Our Ref: EP/140/09/NMA

**Application for non-material amendment with regard to planning permission
EP/144/08 for the addition of two brick quoin details to the north elevation
Land west of Cedar Wood, The Street and south of 11 Copse View, East Preston**

North Elevation

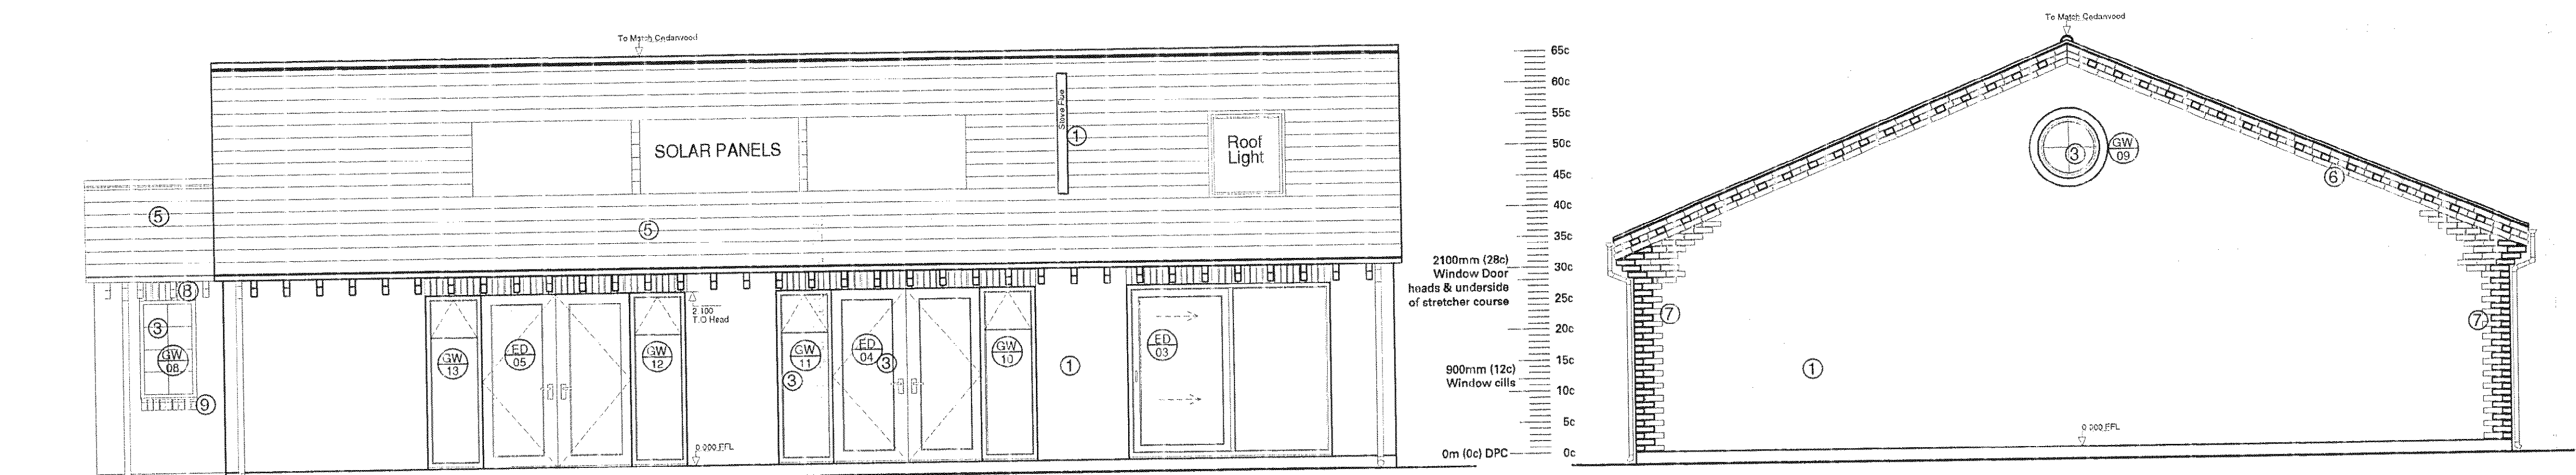
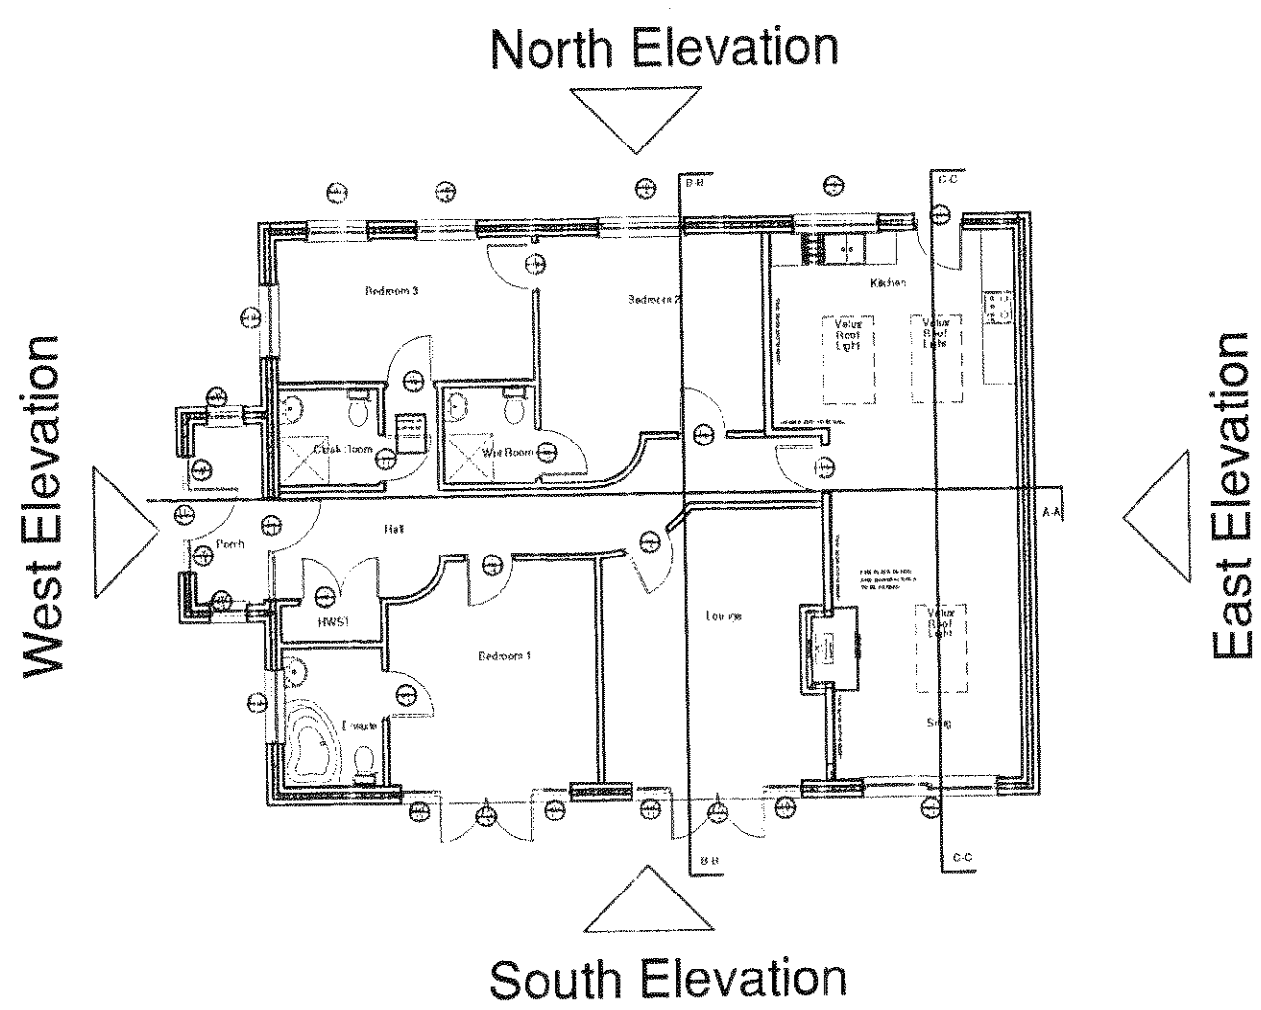
I can advise that the introduction of two central bricks quoin details to the north elevation of the dwelling is acceptable as a minor amendment to the approved plan.
